**Laurie Leader - Re: BP#2014-023767 Newbury Street - Plan review questions**

I am handling the plan review for 73 Newbury Street. Can you please clarify the following:

1
A8
RESTORED SOUTH ELEVATION
SCALE: 1/4" = 1'-0"

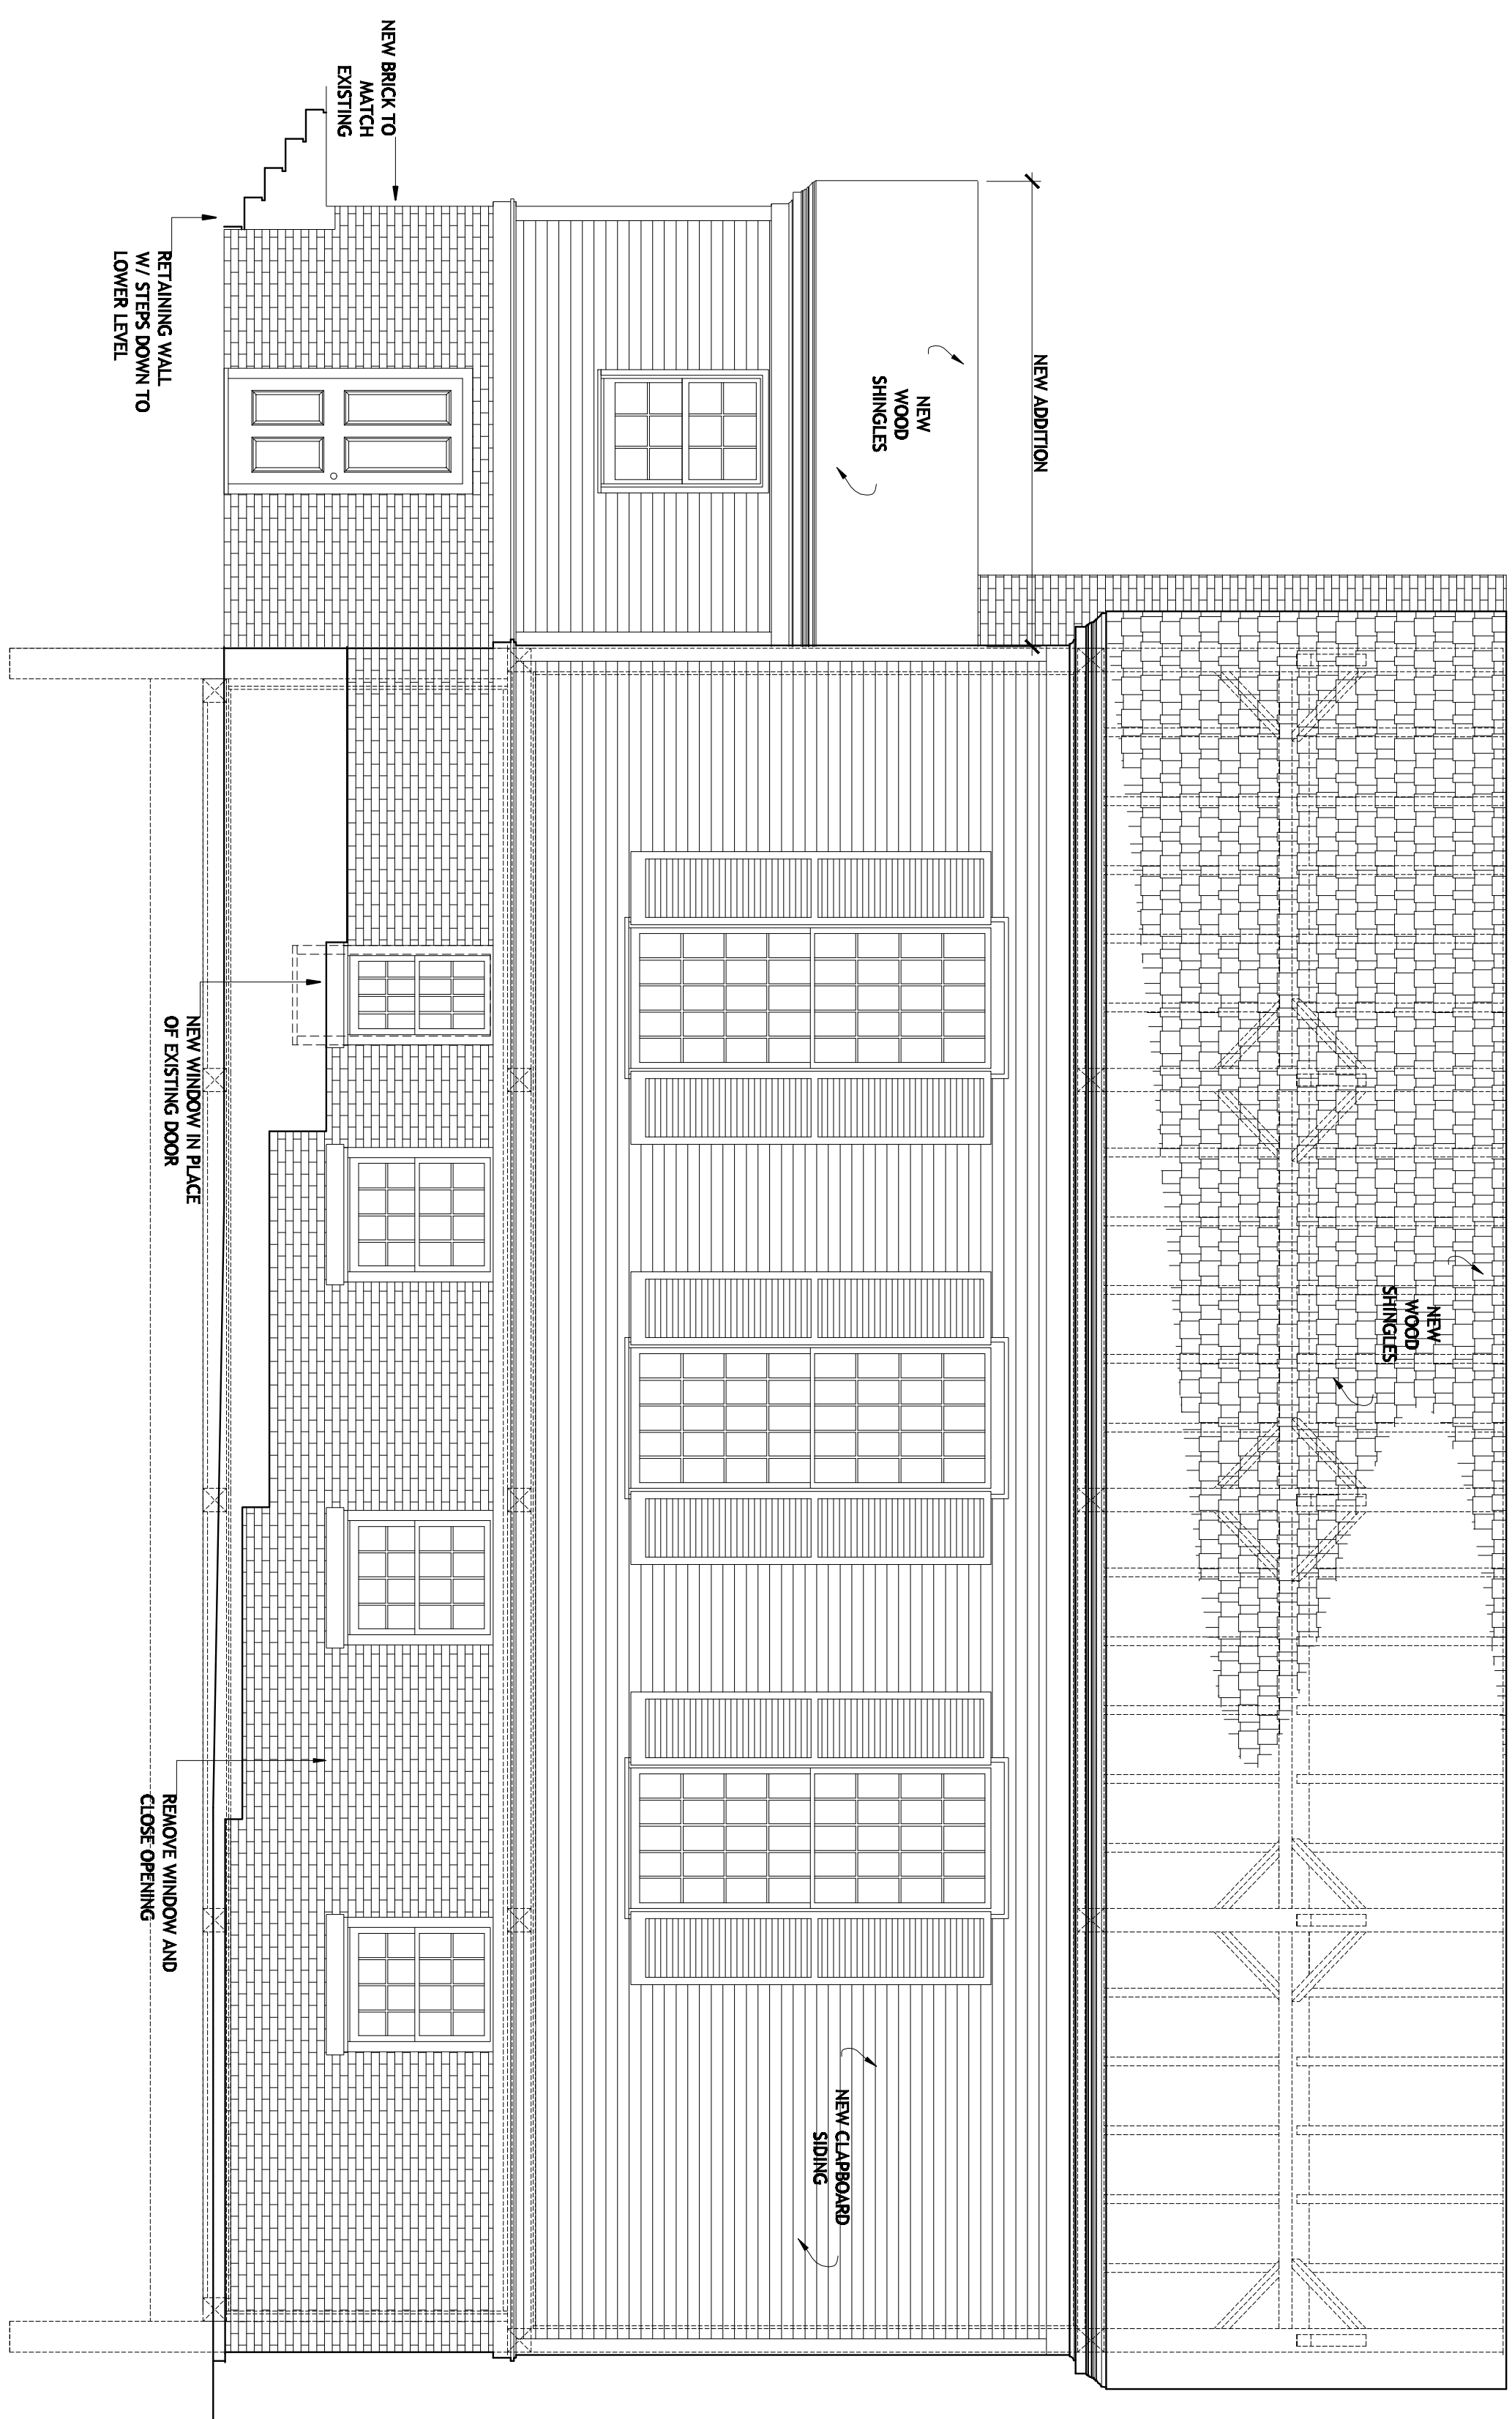
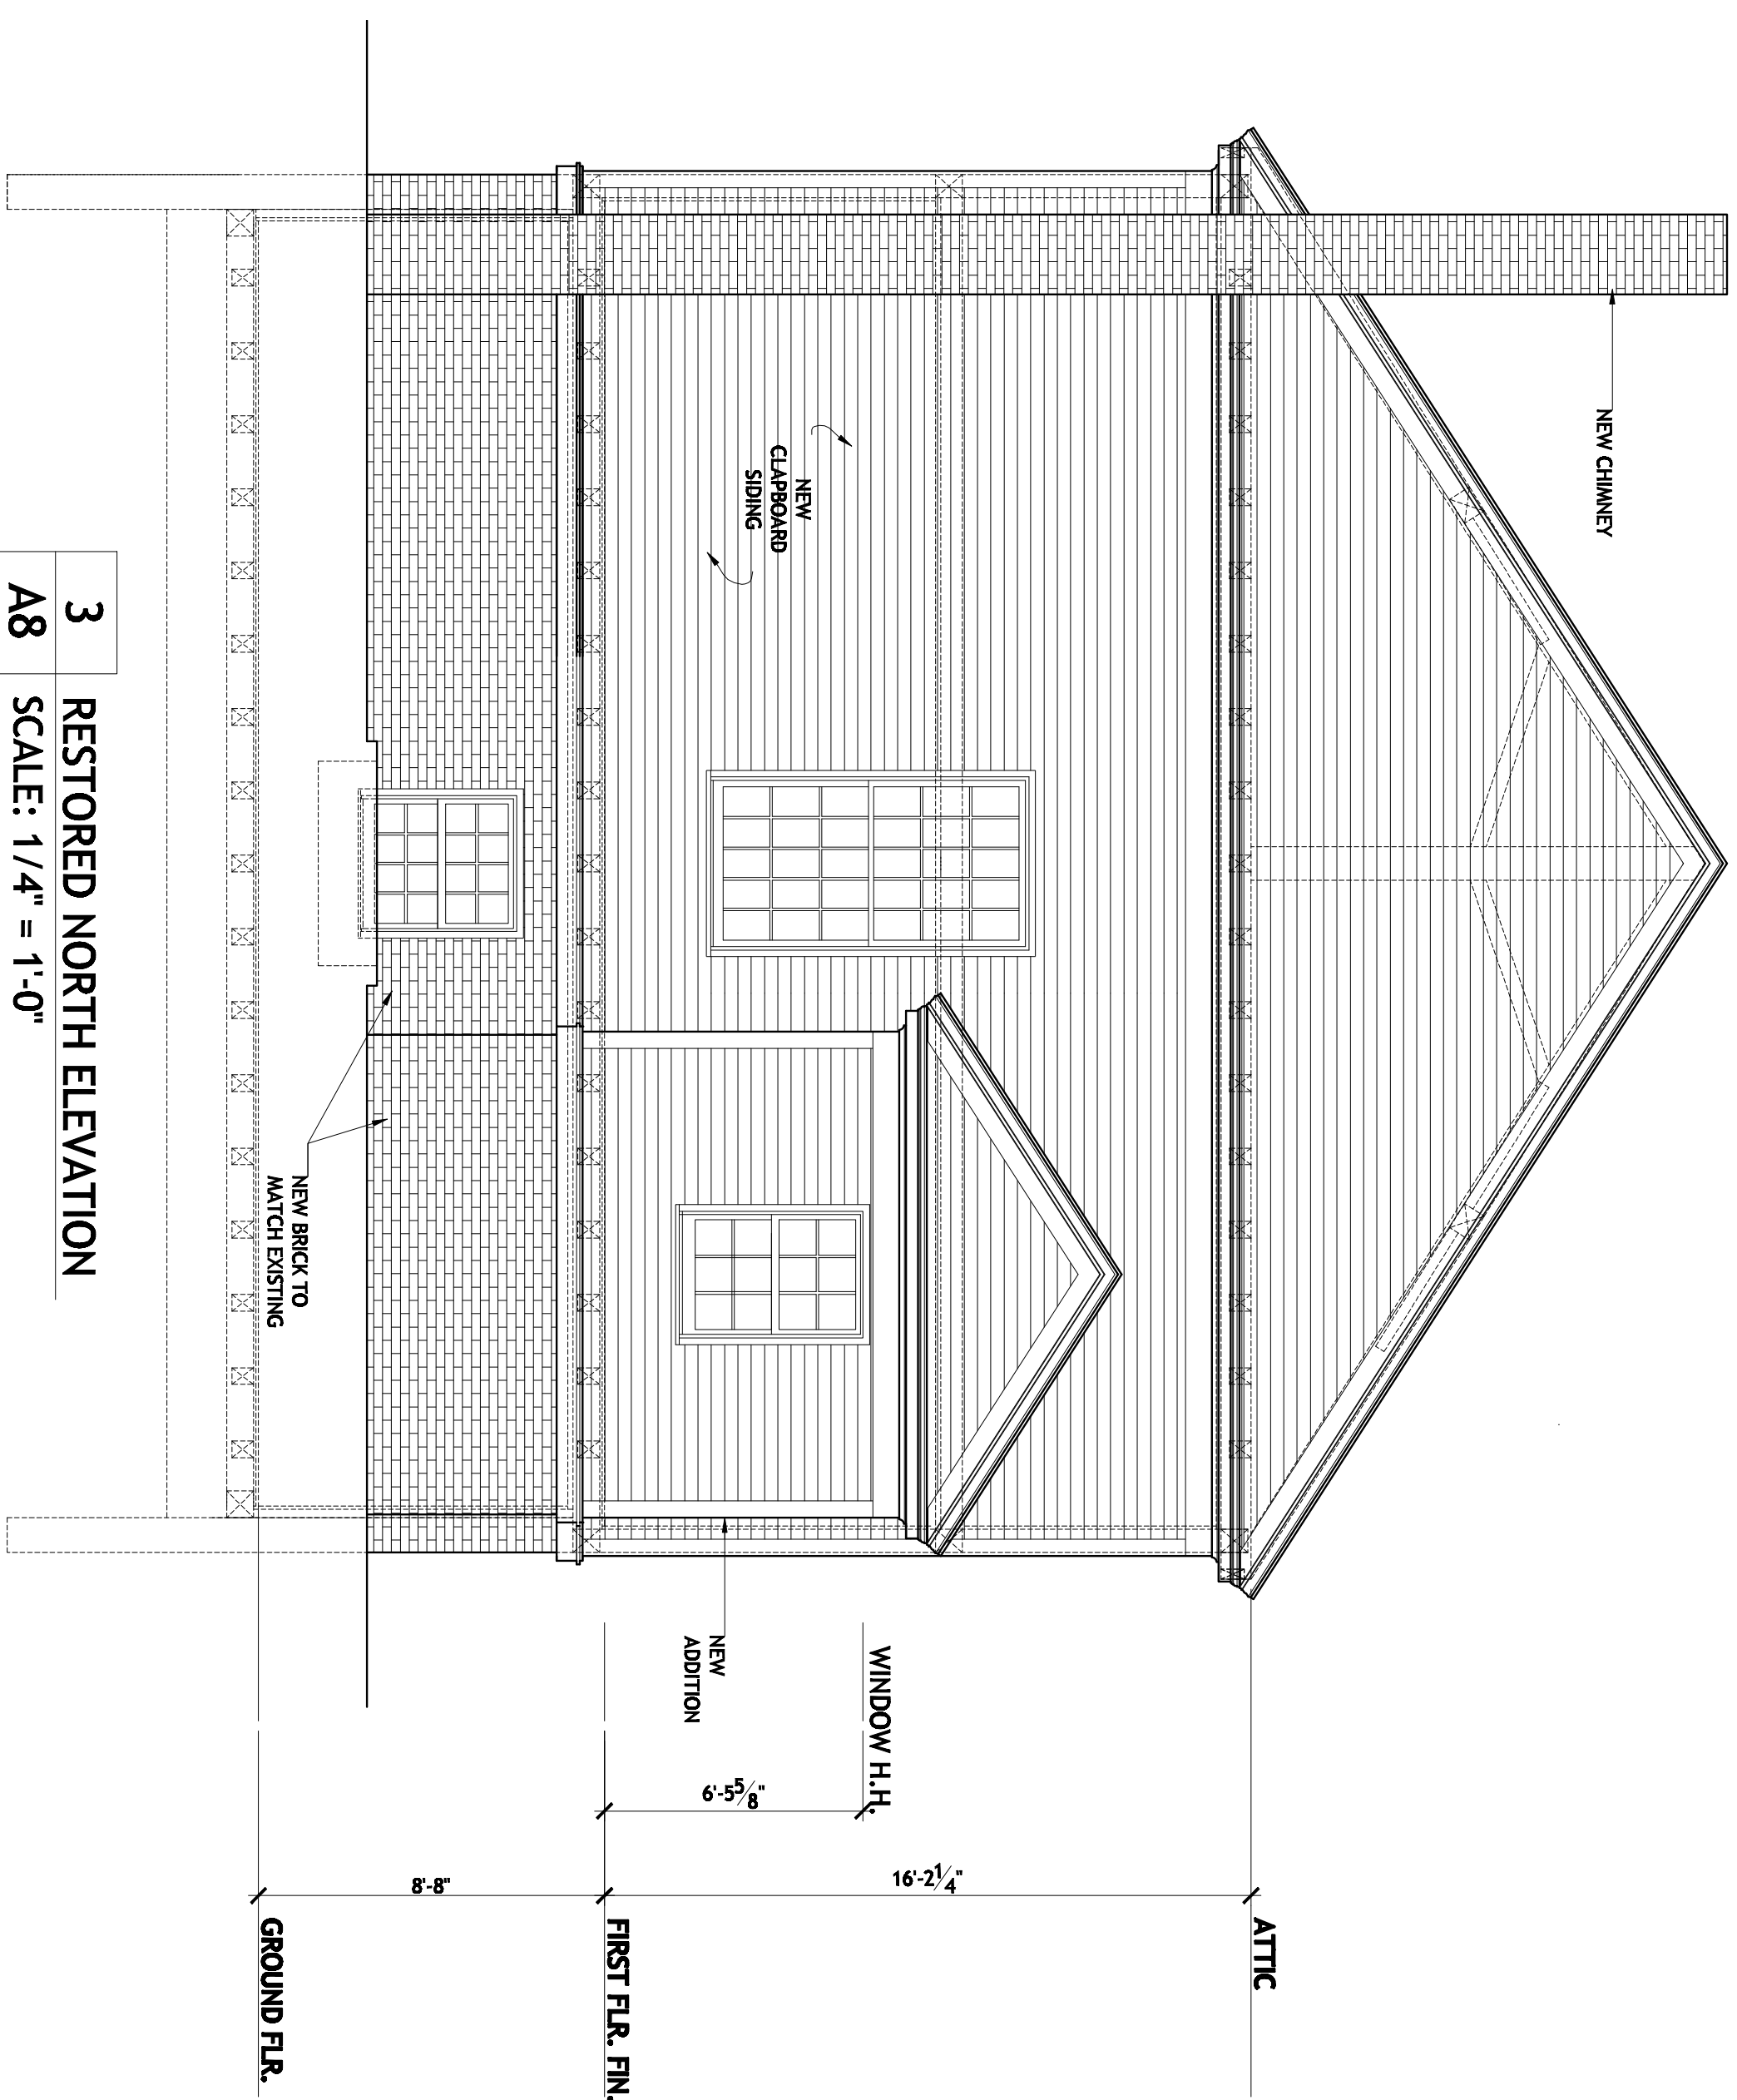
1. Is the use of the building going to be a museum/meeting house or a church/community center?
2. Are windows being installed in the rough openings?
3. Can you clarify what the interior demolition consists of? The plans do not reflect any interior demolition.
4. Can you provide dimensions on the plans for the proposed rough openings?

The rough opening for the windows is 4'x8', this is based on the evidence found during our previous demolition and to match that of the windows in the front gable.
